Our Case Number: ABP-317660-23

Re: Bus Connects Kimmage to City Centre core bus corridor scheme
Kimmage, Dublin

Bus Connects Dublin - Kimmage to City Centre Core Bus Corridor Scheme

Bord Pleanála Case reference: HA29N.317660

Programme Title BUSCONNECTS DUBLIN CORE BUS CORRIDORS INFRASTRUCTURE WORKS				
Drawing Title KIMMAGE TO CITY CENTRE CORE BUS CORRIDOR SCHEME GENERAL ARRANGEMENT				
Drawing File Name BCIDD-ROT-GEO_GA-0011_XX_00-DR-CR-0004	Sheet Number 04 of 14	Status A	Rev M01

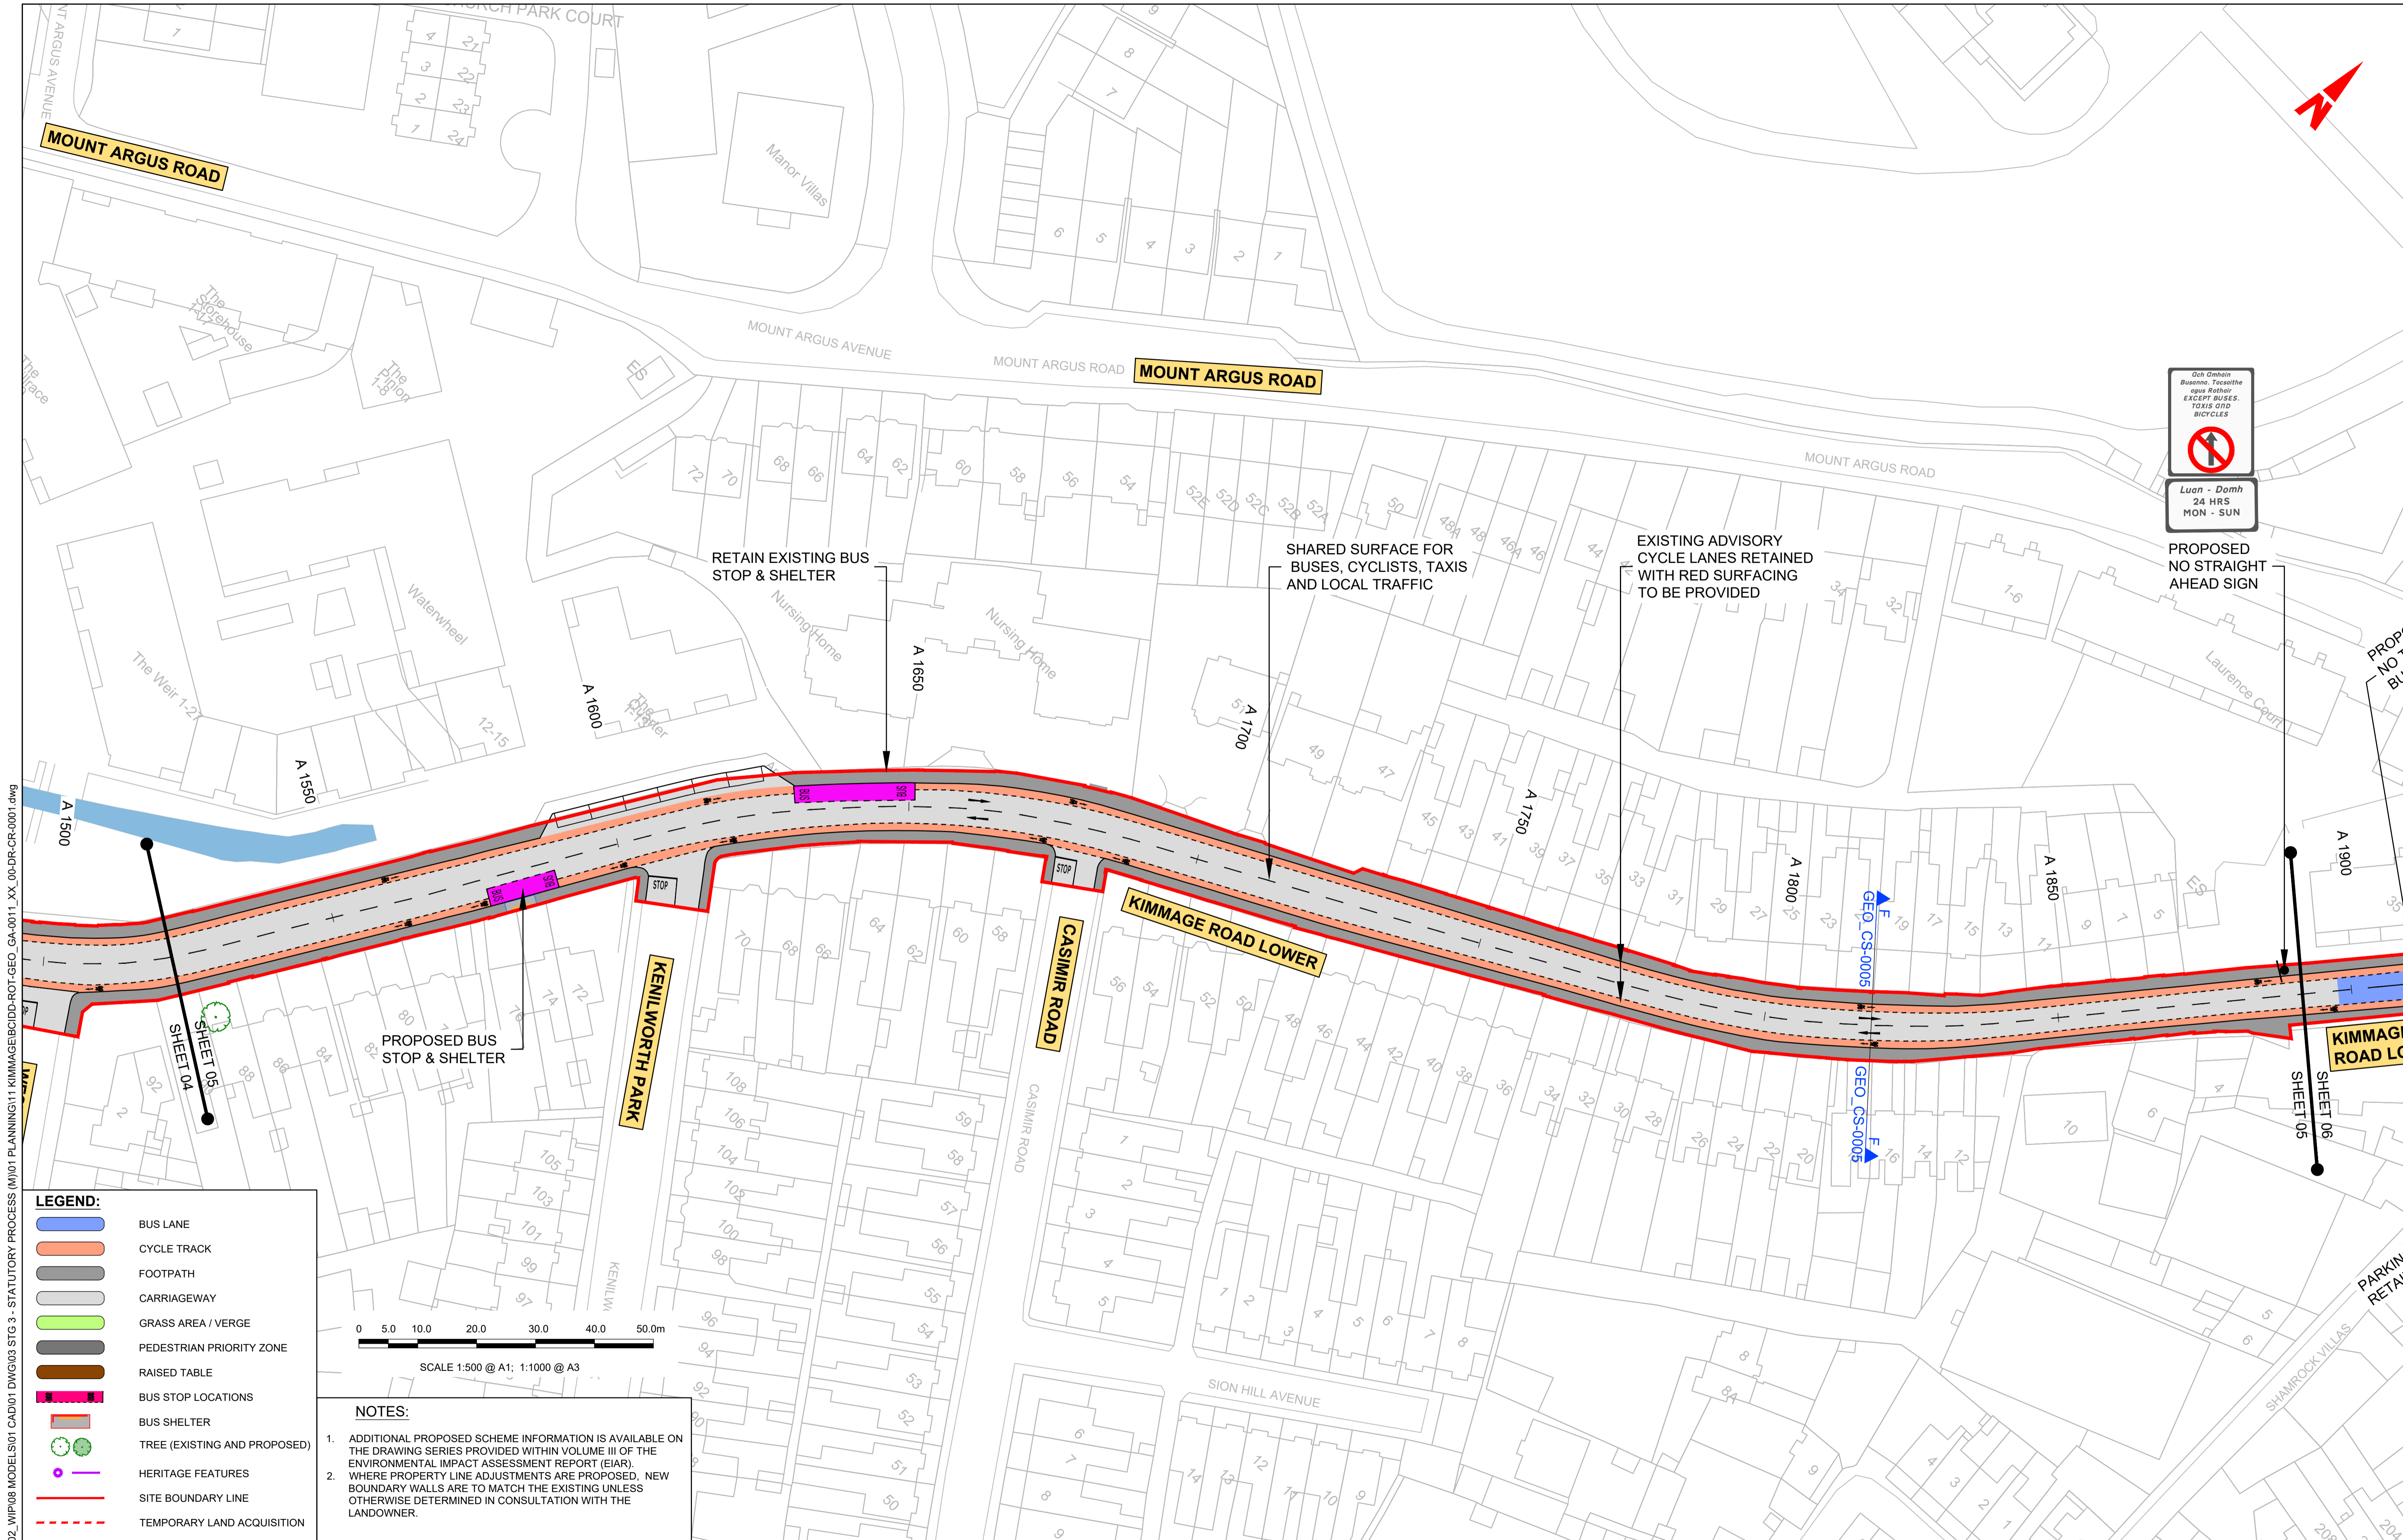
- The proposed construction of a bus stop shelter at bus stop 2391, Priory Road, is impractical due to the narrow width of the pavement at this location. Its introduction will lead to the obstruction of movement of pedestrians including those using mobility vehicles and buggies, (see **Appendix 3**).

Bus Stop number 2391 - Shelter located at Priory Road – **OBJECTION:**

- The proposed introduction of this Bus shelter is impractical due to the narrow width of the pavement at this location. Its introduction will lead to obstruction of movement of pedestrians including those using mobility vehicles and buggies.

I request that the developers are instructed not to proceed with plans to build a bus shelter at this location
